Ribble Valley Borough Council
Council Offices
Church Walk,
Clitheroe
Lancashire
BB7 2RA

Phone: 0300 123 6780
Email: developeras@lancashire.gov.uk
Your ref: 3/2025/0597
Our ref: 3/2025/0597/HDC/KW
Date: 09 September 2025

Location: 70-74 Bawdlands Clitheroe BB7 2LA
Proposal: Retrospective application for change of use of ground floor from hot food takeaway (sui generis) to additional living accommodation for the existing dwelling (C3).
Grid Ref: 373927 441615

Figure 1: Ground floor layout of 70-74 Bawdlands (party wall to 76 Bawdlands highlighted in red, commercial Use Class E side of 76 Bawdlands highlighted in blue)

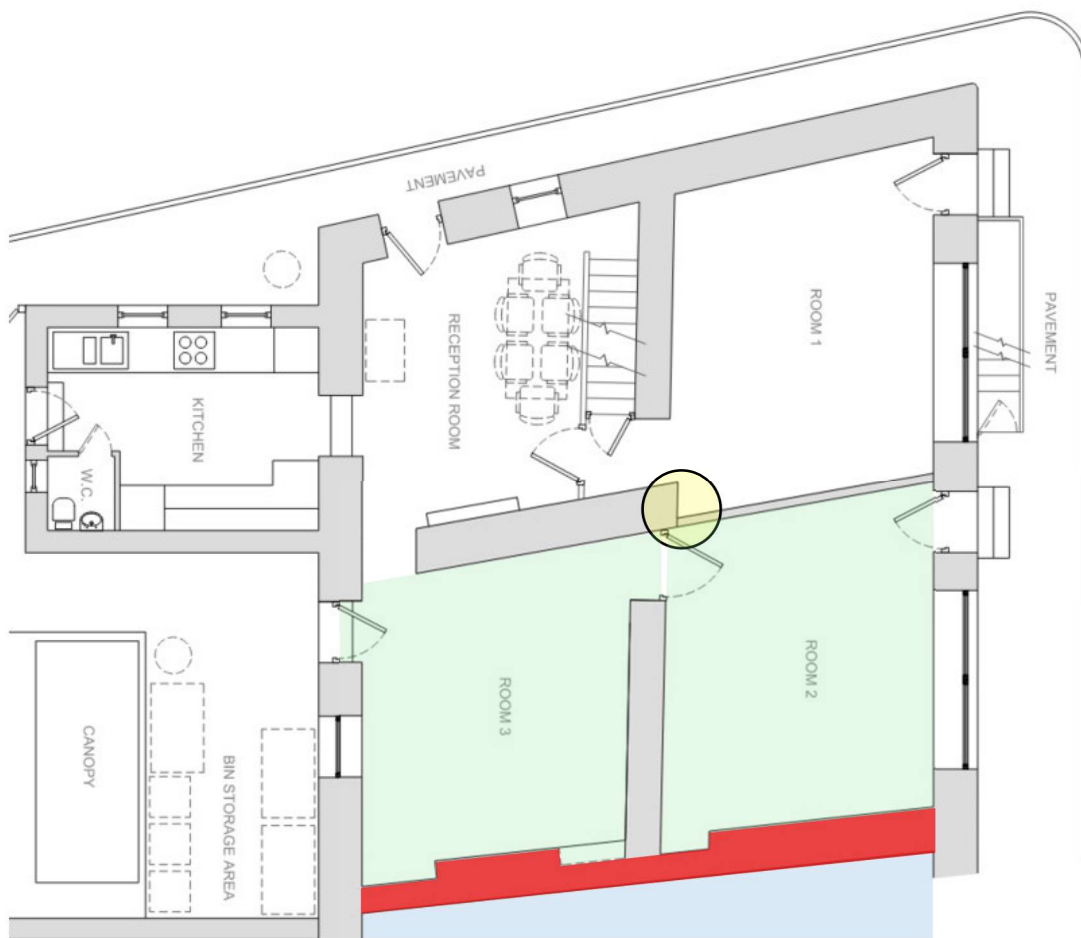
The site will retain the existing pedestrian accesses onto Bawdlands, which is classified as the B6243 with a speed limit of 20mph. There is also an existing pedestrian and vehicle access to a garage situated at the East of the site.

The existing garage does not meet the recommended internal dimensions of 3m wide and 6m long to be considered an acceptable size to accommodate off street parking, it can however, provide covered and secure cycle parking, which supports sustainable transport use.

1. Secure cycle storage suitable for 2 bicycles shall be provided within the development. Reason: To promote sustainable transport as a travel option, encourage healthy communities and reduce carbon emissions.
